From: Andrew Wood <Andrew.Wood@arun.gov.uk>
Sent: 23 October 2019 11:39
To: Richard Sloman [REDACTED]
Cc: Planning.Responses <Planning.Responses@arun.gov.uk>
Subject: FW: A/104/19/RES

Planning Application Ref: A/104/19/RES

Location: Crete Nursery, Dappers Lane, Angmering, BN16 4EN

Description of works: Approval of reserved matters following A/178/17/OUT for the demolition of existing outbuildings with retention of existing dwelling & erection of 6no. dwellings

Plate 2: Garden & Boundary Fences

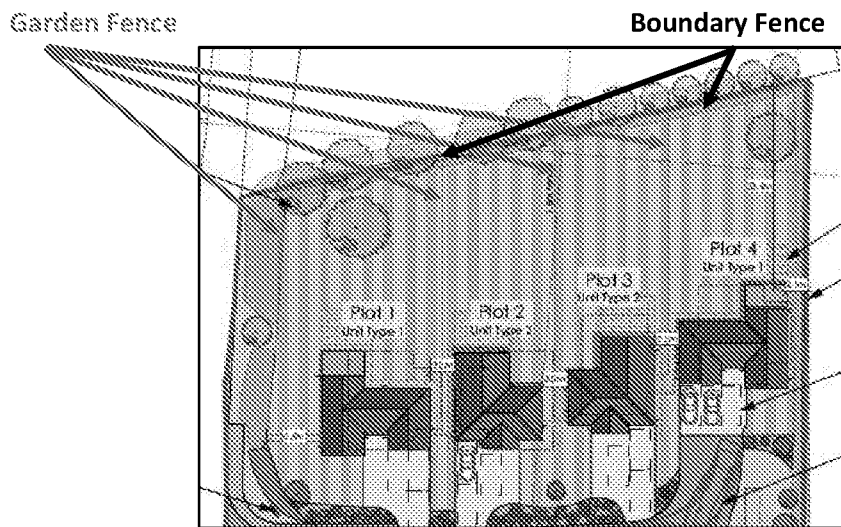
Para.3 - The AMS does not cover in enough detail what is happening with the boundary fencing and garden division fencing within the RPA of the screen of hornbeam trees to the north and off-site – mitigation measures and methodology required here.

Plate 4: RPA of T07 in Relation to the Existing Hardstanding Access Track
Dominant Category A Oak Tree (T07) With 9.15m RPA Superimposed

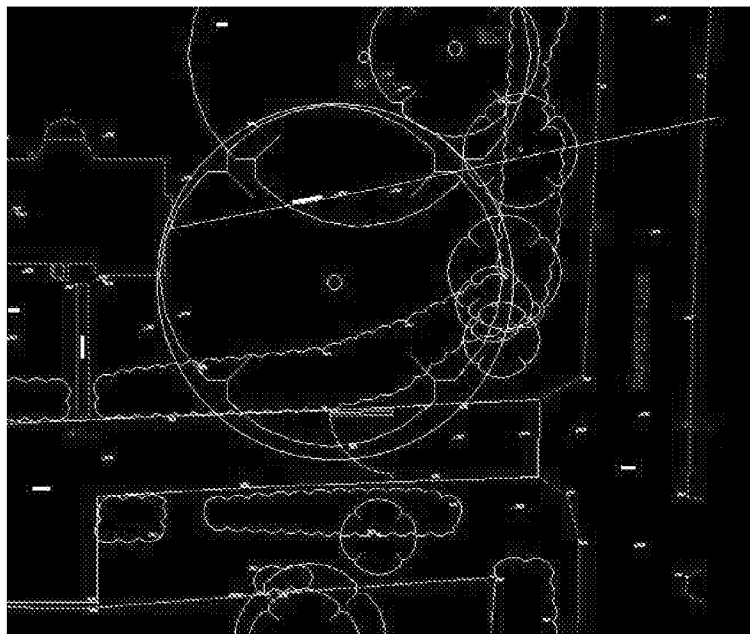
Para.4 – The AMS does not detail exactly what is happening and the mitigation measures and methodology required here for any revisions to the access drive (widening or resurfacing) that appear to be taking place.
